Town & Country Planning Act 1990 (as amended)
Town & country Planning (Development Management Procedure) (England) Order 2015

Ground & first floor rear extension, new roof on existing shed & hip to gable end to join garage & shed.

5 Barbary Lane Ferring

Thank you for your internet representation made on 14th May 2018 which has been recorded as '**an objection**' with the comments as follows:

ROOF PLAN
AS PROPOSED

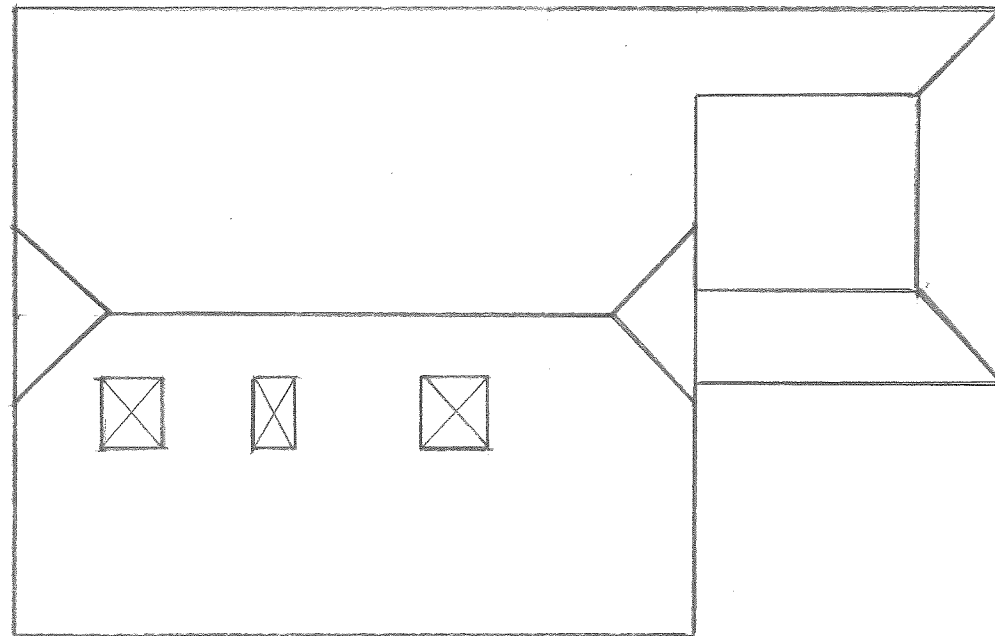
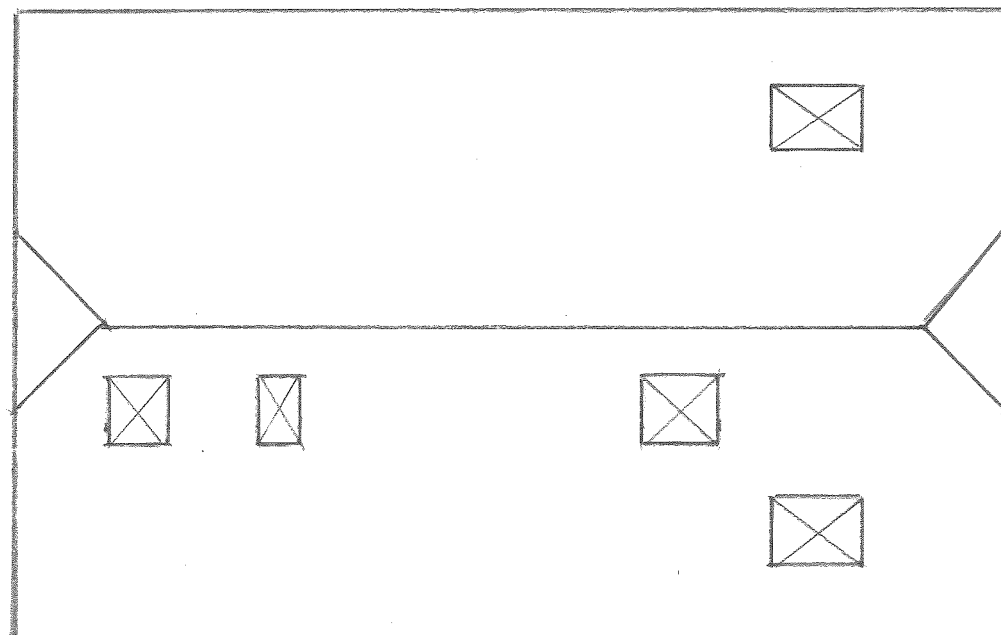
It will be detrimental to us to increase the height of the shed. The proposed building would have an overbearing impact on both us and our property.

SOUTH ELEVATION
AS PROPOSED

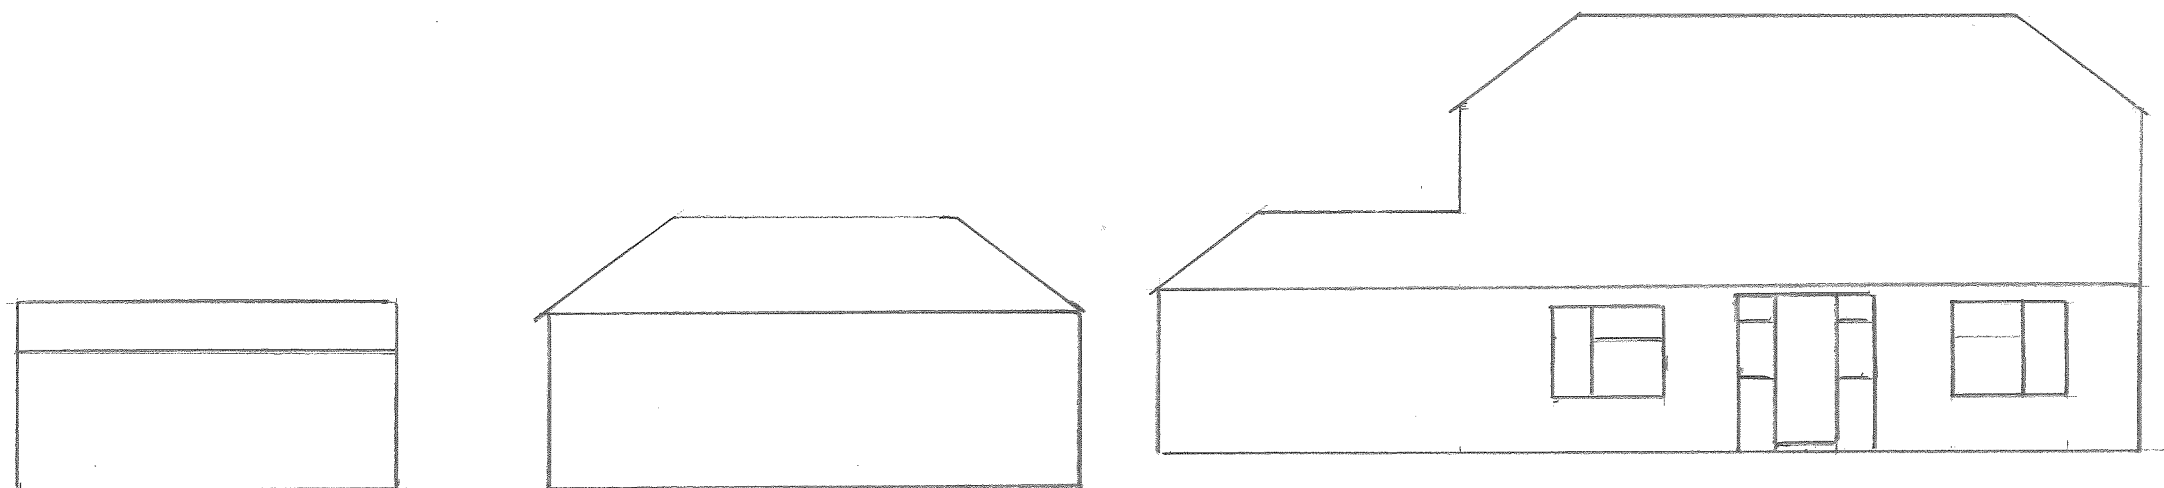
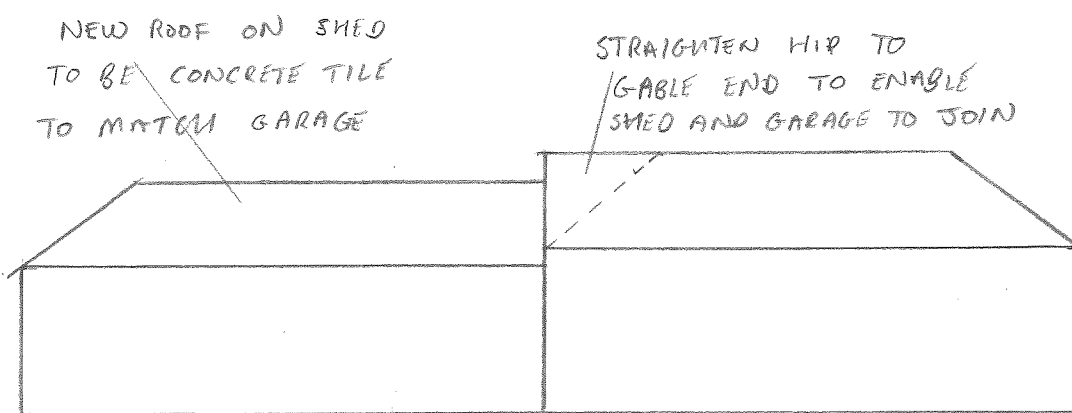
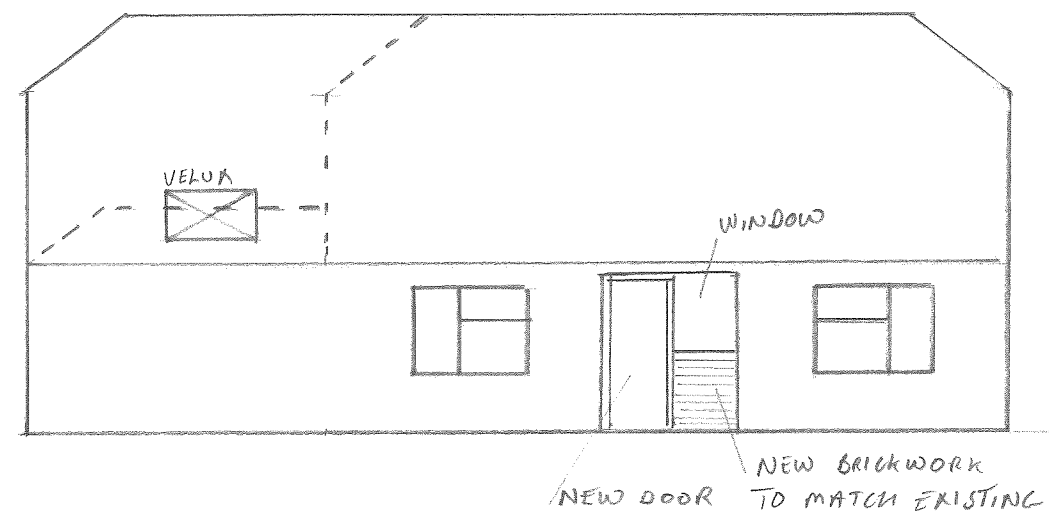
The proposed velux window in the roof on the south elevation of number 5 Barbary would greatly affect our privacy when in our patio/garden.
